Byron Shire Central Hospital, Ewingsdale (SSD 6573)

Thank you for your letter dated 15 August 2014, requesting Transport for NSW (TfNSW) to review and comment on the above development application. A separate response will be provided by Roads and Maritime Services (RMS).

CD14/15469

Site Plan

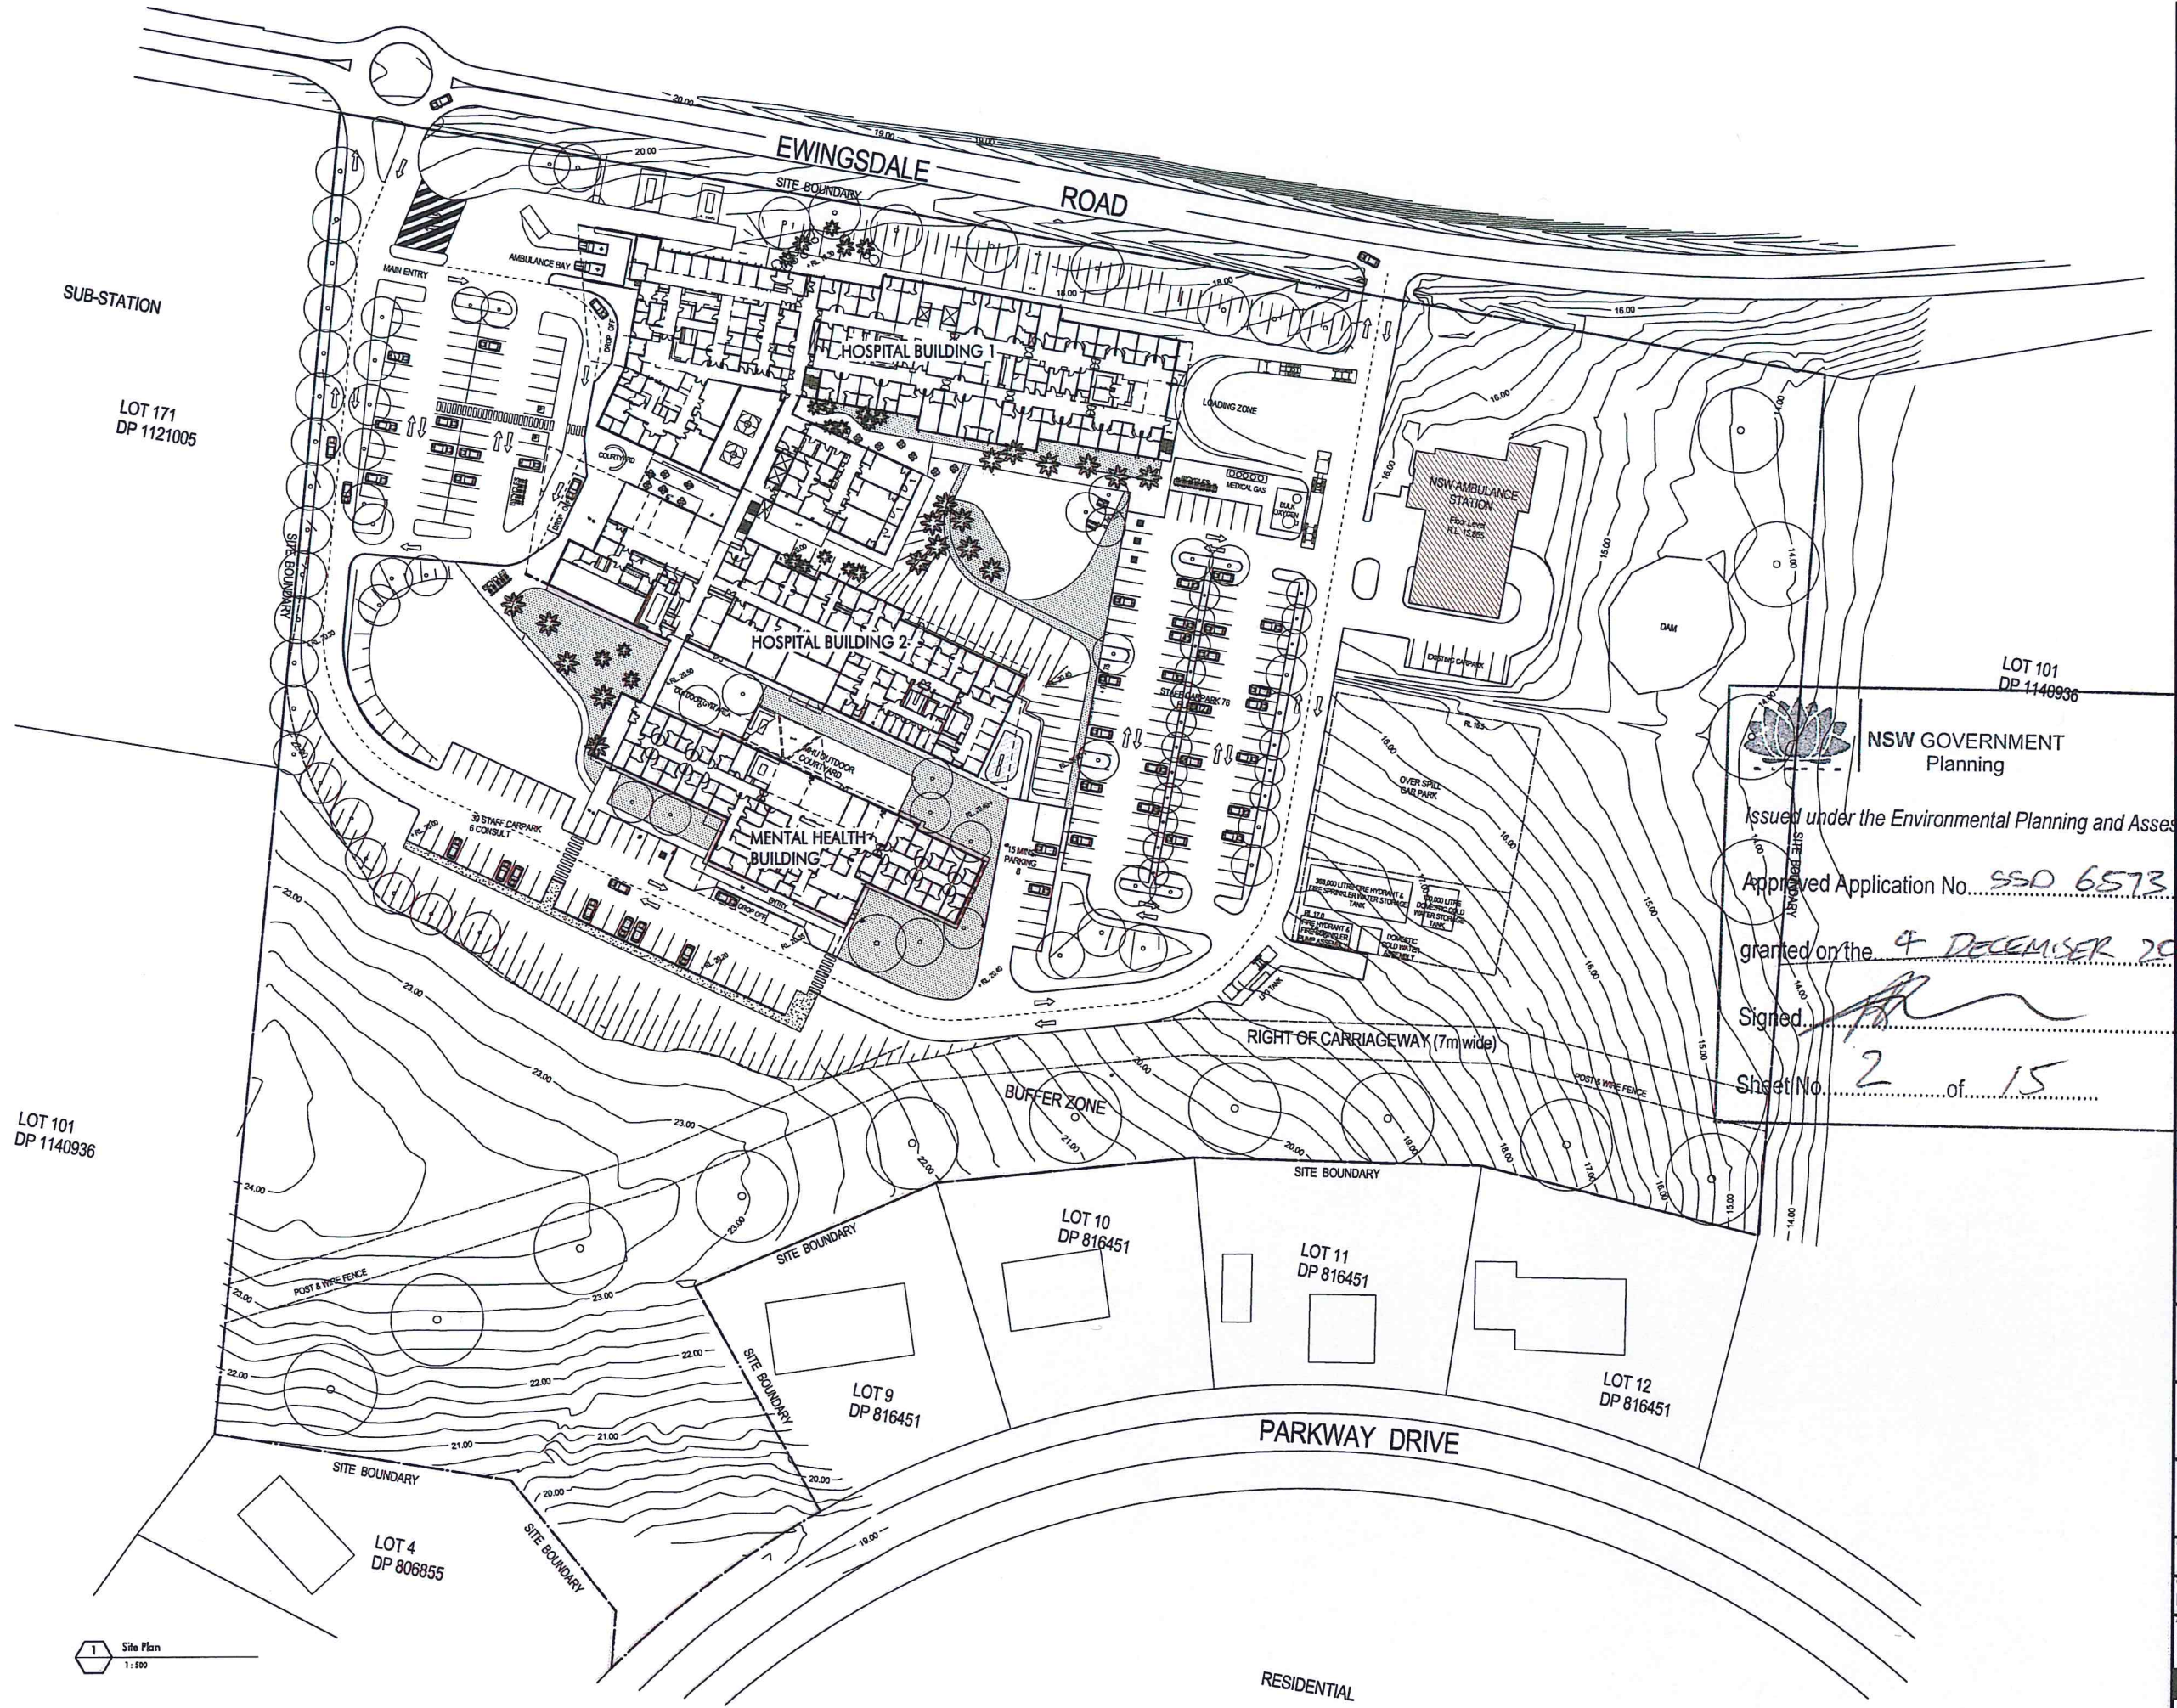
- TfNSW requests that designated parking spaces be provided for patients, in particular for patients visiting emergency department, chemotherapy services and maternity services. These parking spaces need to be provided in the nearest car parking areas to the treatment rooms to minimise the walking distance to/from treatment rooms.

- TfNSW requests that designated taxi pick up and drop off areas be provided within the hospital site.

- TfNSW requests that the applicant provides bike parking facilities in accordance with relevant Australian Standards (AS2890.3 Bicycle Parking Facilities). Each bike parking facility shall be located in easy to access, well lit areas that incorporate passive surveillance.

- TfNSW requests that the applicant provides bus facilities such as bus stops, access to bus stops etc. within the proposed hospital site in consultation with bus operators and Byron Bay Shire council.
